HISTORIC BUILDINGS AND CONSERVATION ADVICE

RE: Great Nast Hyde House, Wilkins Green Lane, Hatfield, AL10 9RB

The application is for the approval of details pursuant to condition 3(v) (internal lighting) on planning permission 6/2016/1650/LB.

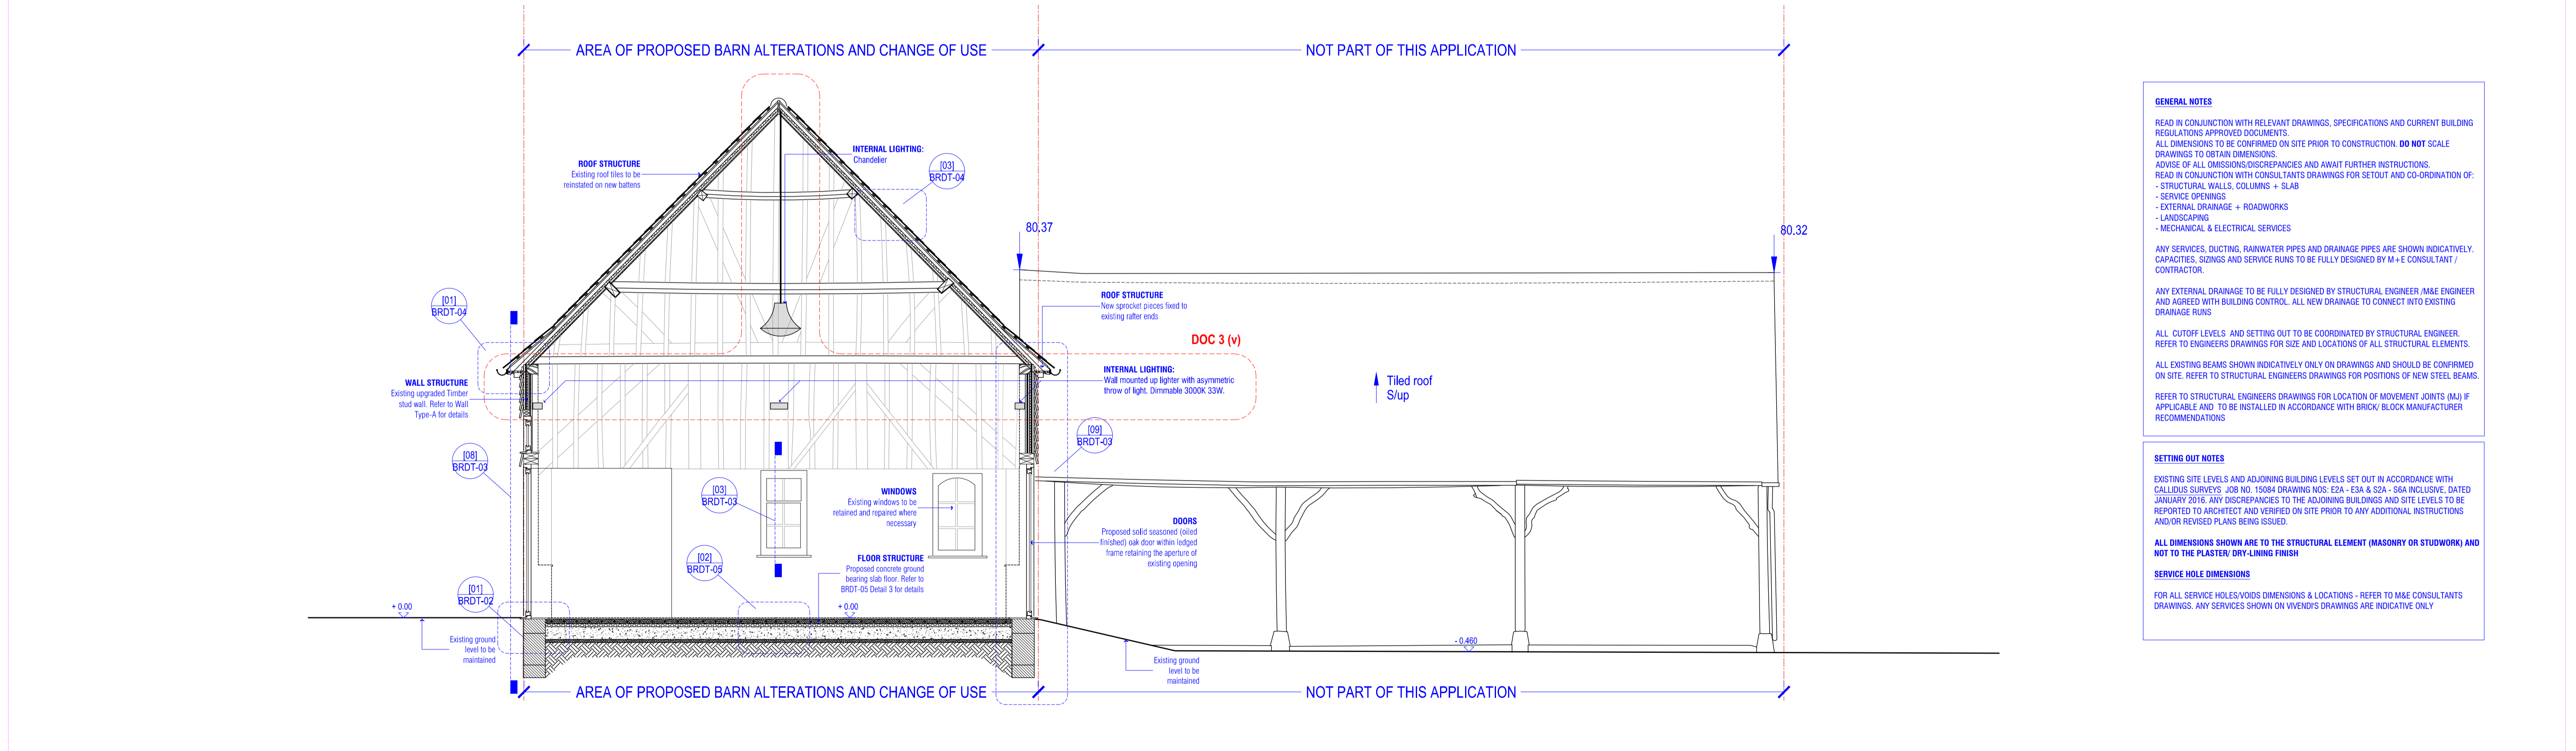
The details submitted (white wall mounted uplighters fixed to white plaster infill panels between rafters) are considered to be acceptable and will not harm the special interest of the building.
